2 Flide Street Caringbah Affordable Housing

Homes NSW

RTS (Response to Submissions)

25th February 2026

Drawing Title
**DA03 - General Arrangement Plans
Level 15 - Roof**

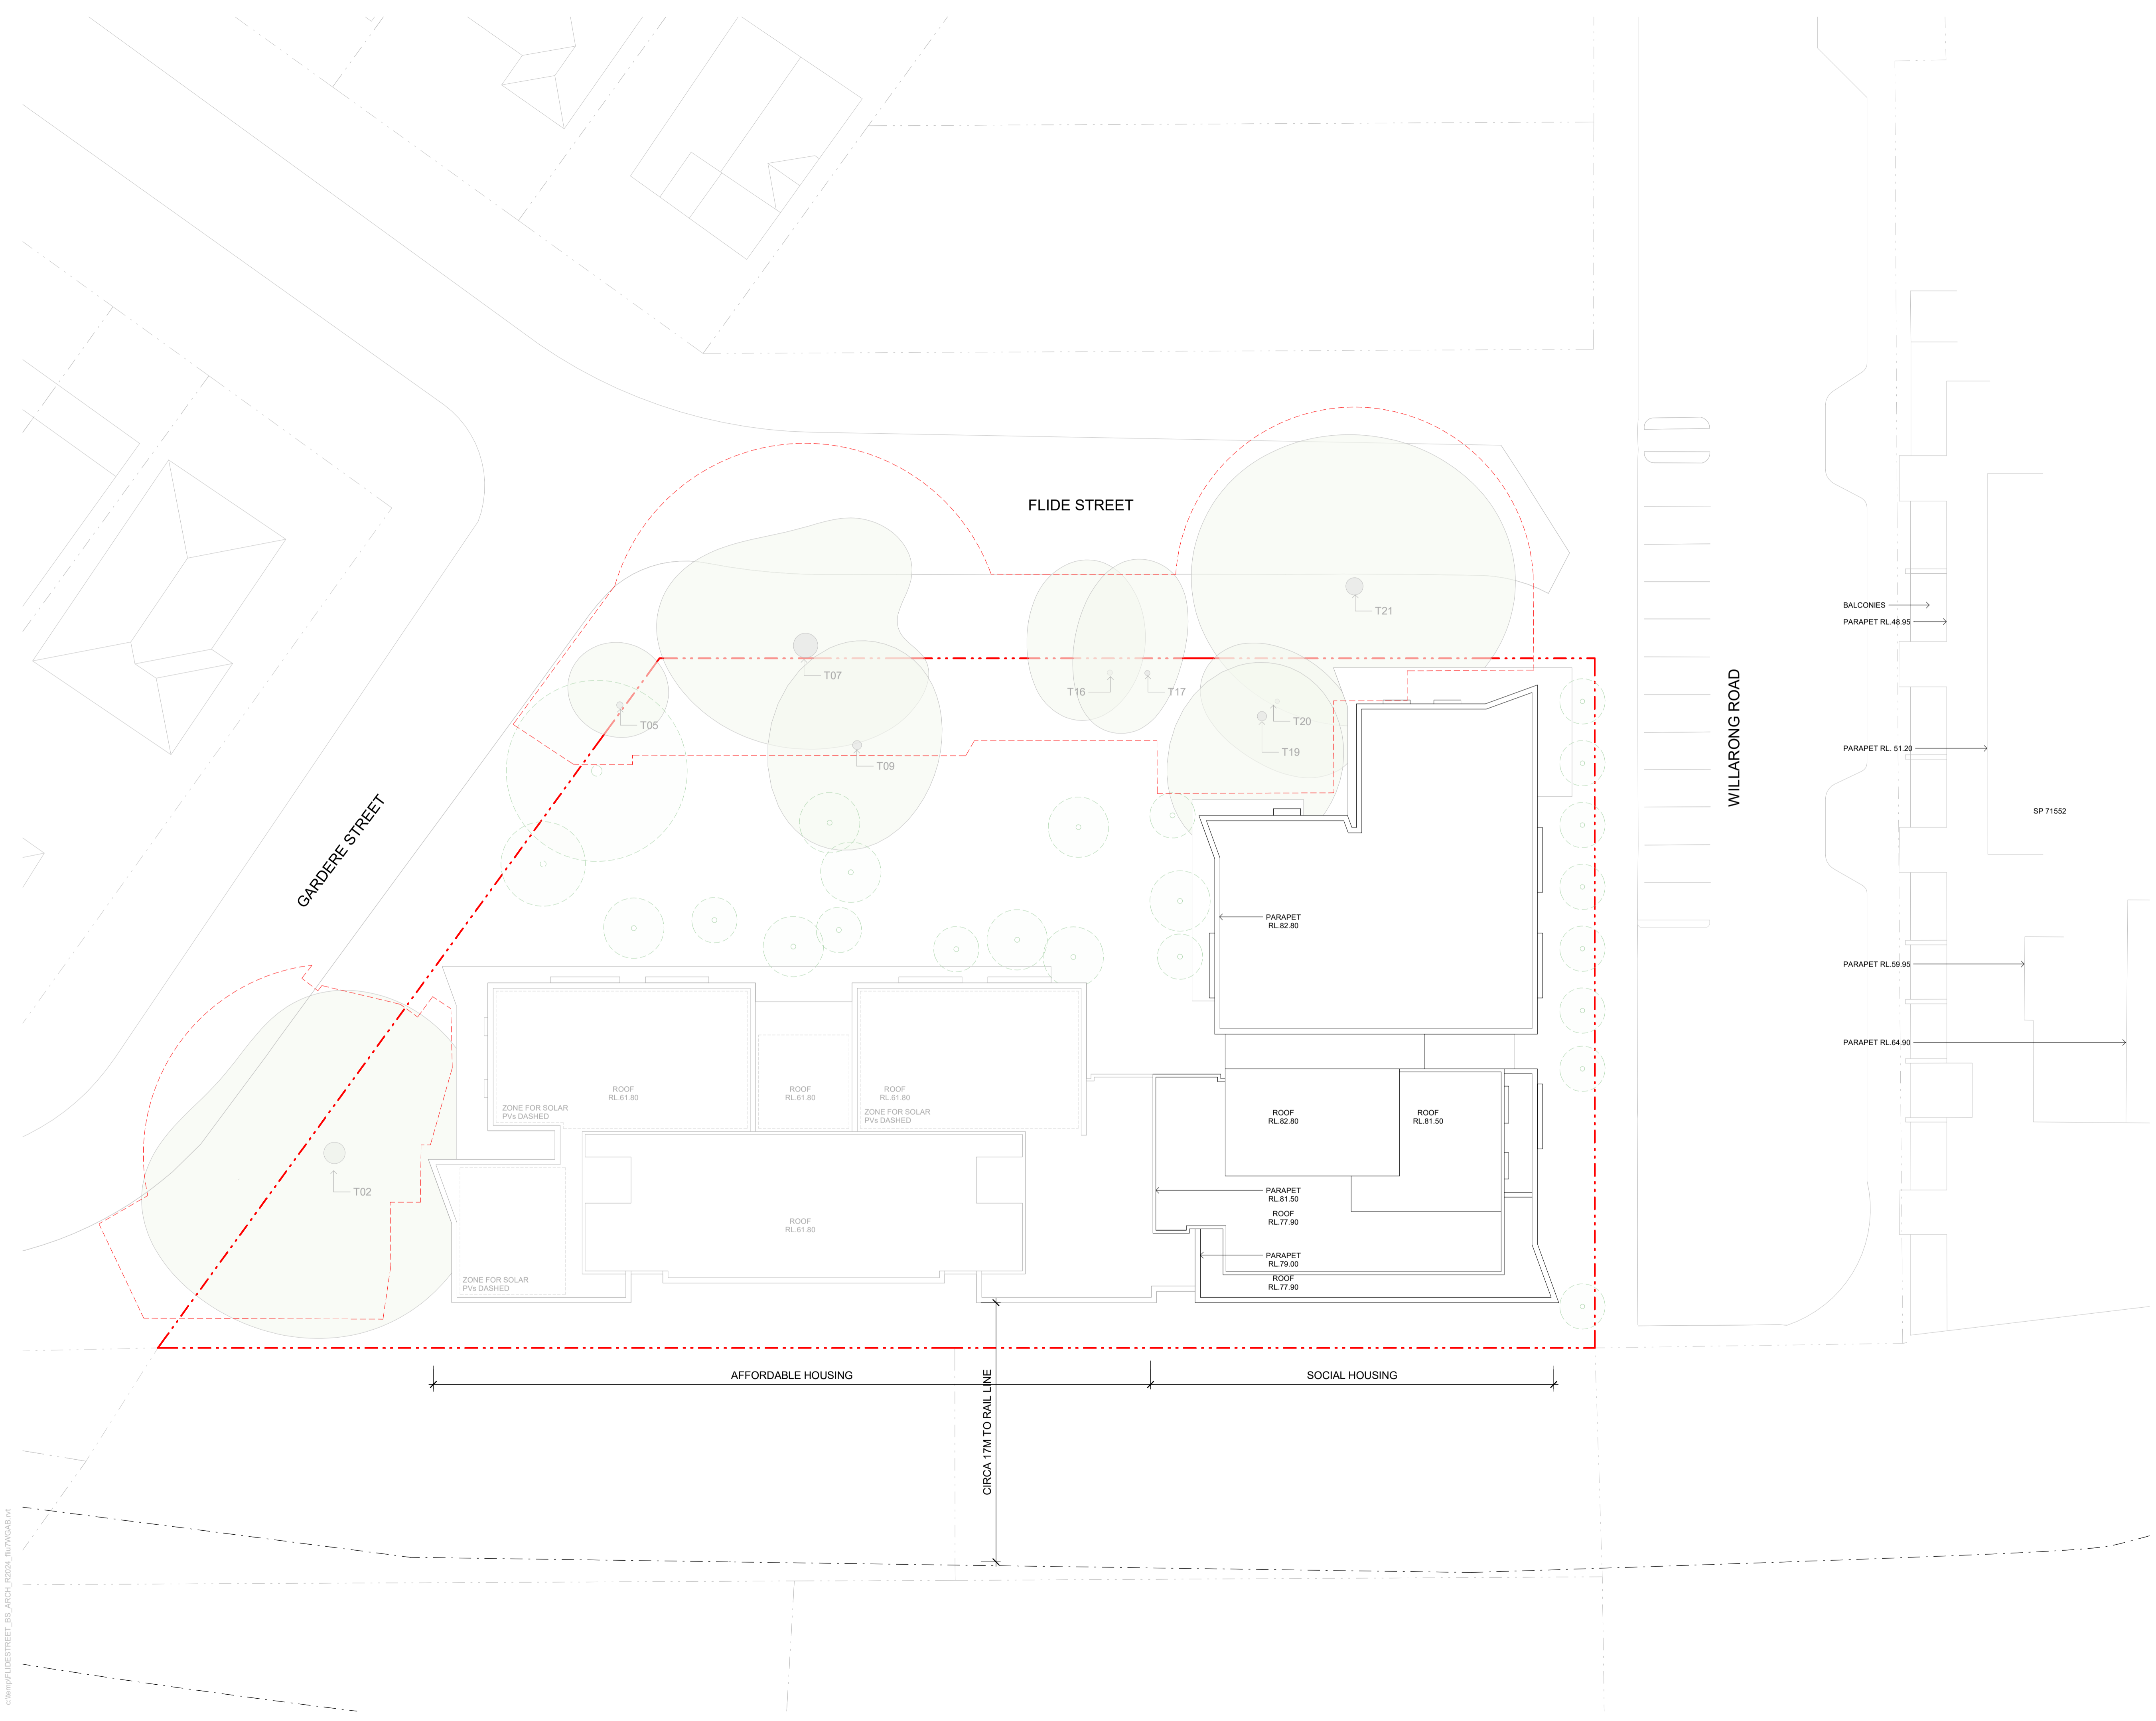
17. Solar PVs relocated
18. Roof extents and height adjusted

9 TYPE - SH-2B-C 1 : 100

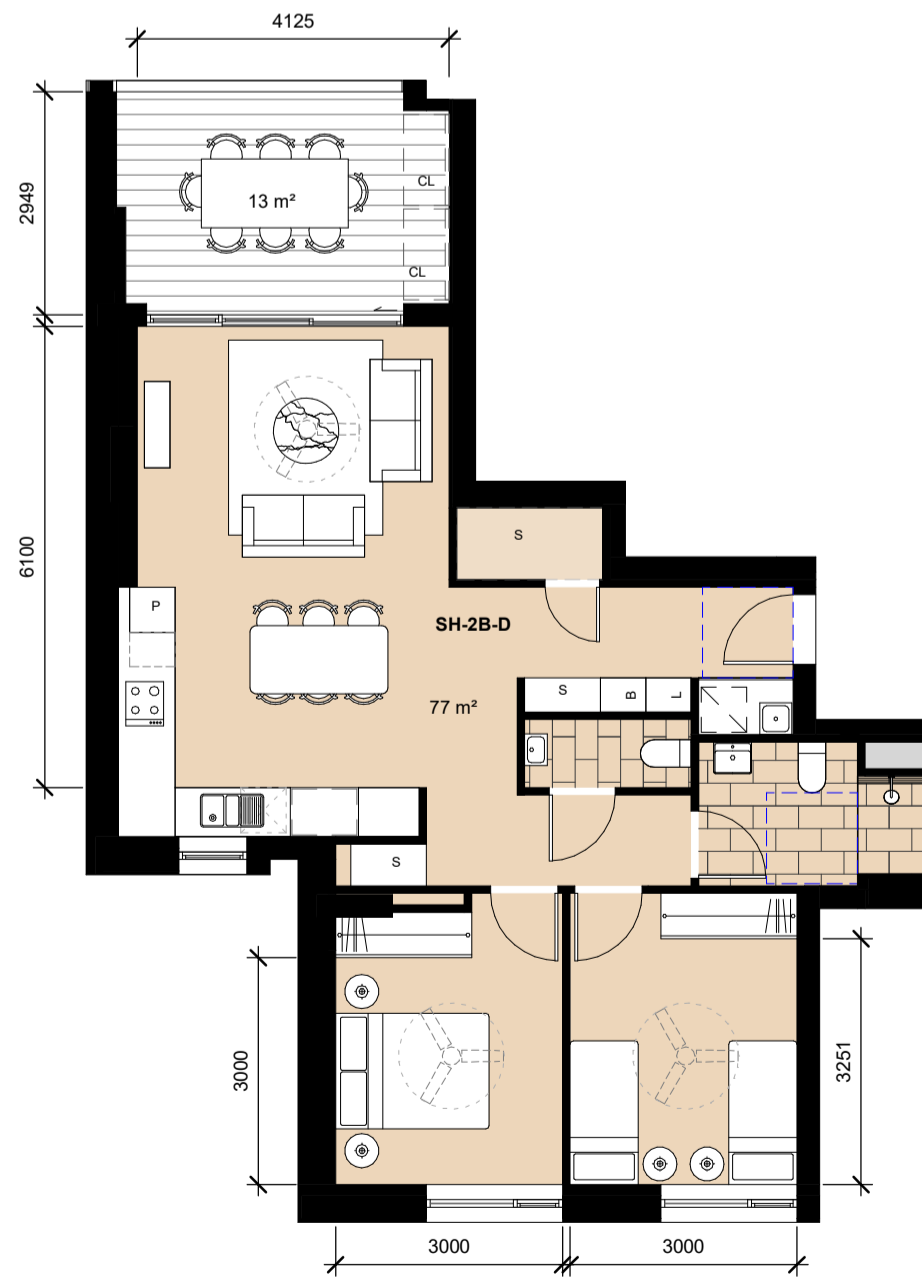
19. SH-2B-C: full-height mesh screen adopted
20. AH-2B-D: wintergarden condition with glazed louvres
